**RE: 2 Australia Avenue, Sydney Olympic Park  
Major Project Application MP10\_0168**

We write on behalf of Capital Corporation to provide a written response to the design issues raised by the SOPA Design Review Panel meeting of 29 March 2012. This response should be read in conjunction with the amended architectural drawings issued to SOPA today and the traffic and access advice prepared by Traffix and accompanying this letter at **Attachment A**.

TYPICAL SECTION - GREEN WALL WITH HANGING SPECIES
PLANT TO FALL DOWN OVER FLOOR HEIGHT SPACE. TRELLIS FRAME NOT REQUIRED.

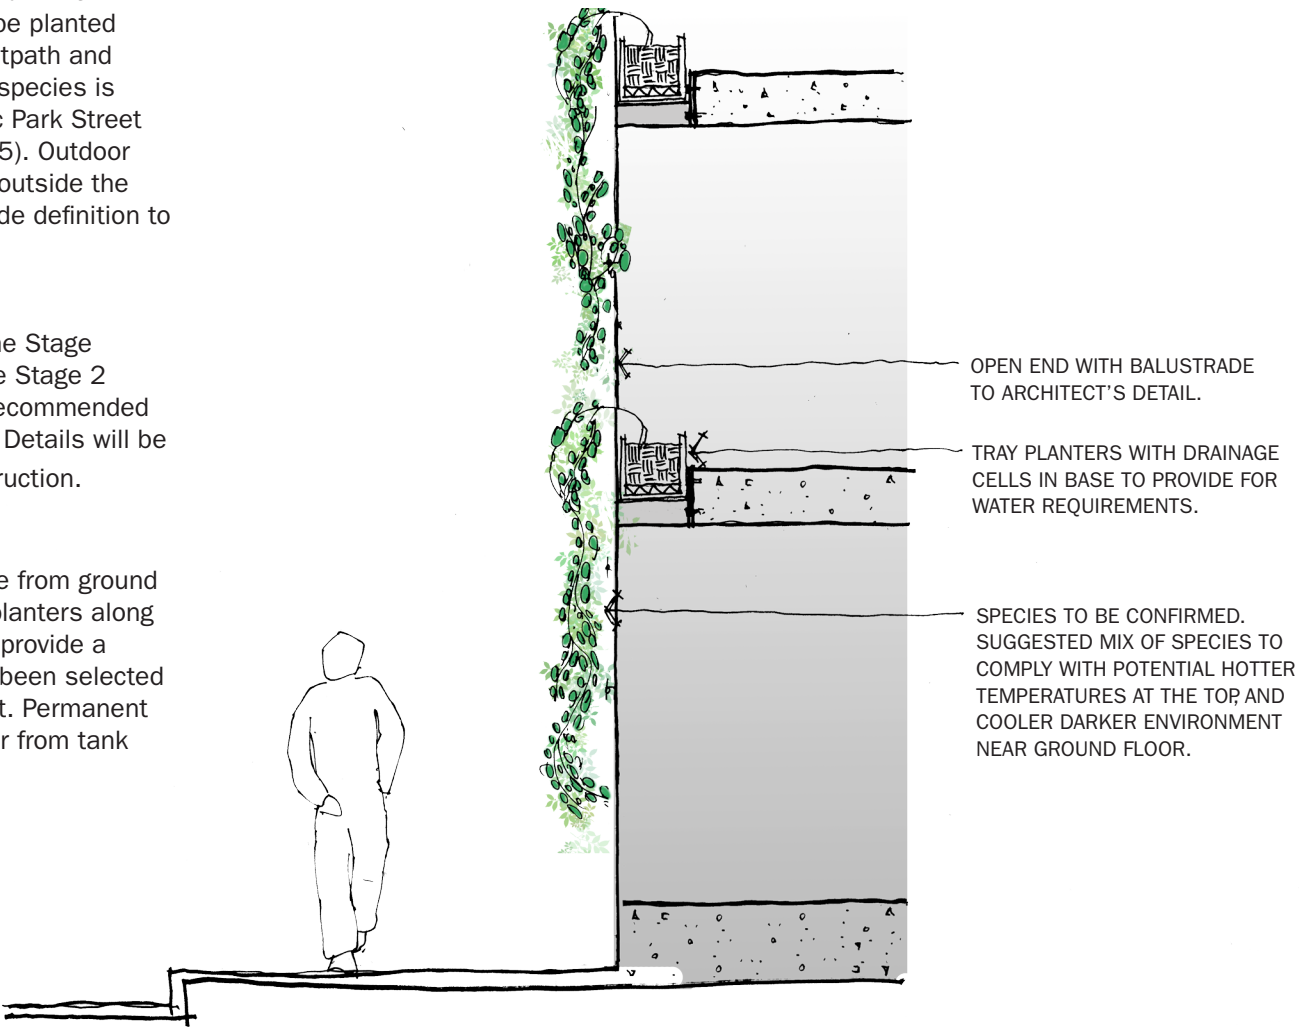
- Architecturally the volumes of the proposed design are satisfactory however the façade treatment is bland and there is a desire from the jury for warmth and animation;
- The Jury strongly support the use of an alternate palette of materials in lieu of alpolic and metallic finishes;
- The Jury is accepting of the verticality and use of solid façade elements; further review is required as to the ongoing maintenance of the proposed Green Wall and Green Screen. Concern was raised as to whether this will be an effective façade treatment for years to come.

The proposed green wall identified in the winning design competition entry has been assessed in detail and it was agreed that the long term result would be detrimental to the building and in turn the precinct.

This was identified and accepted in principle by SOPA during the meeting held 29<sup>th</sup> March 2012.
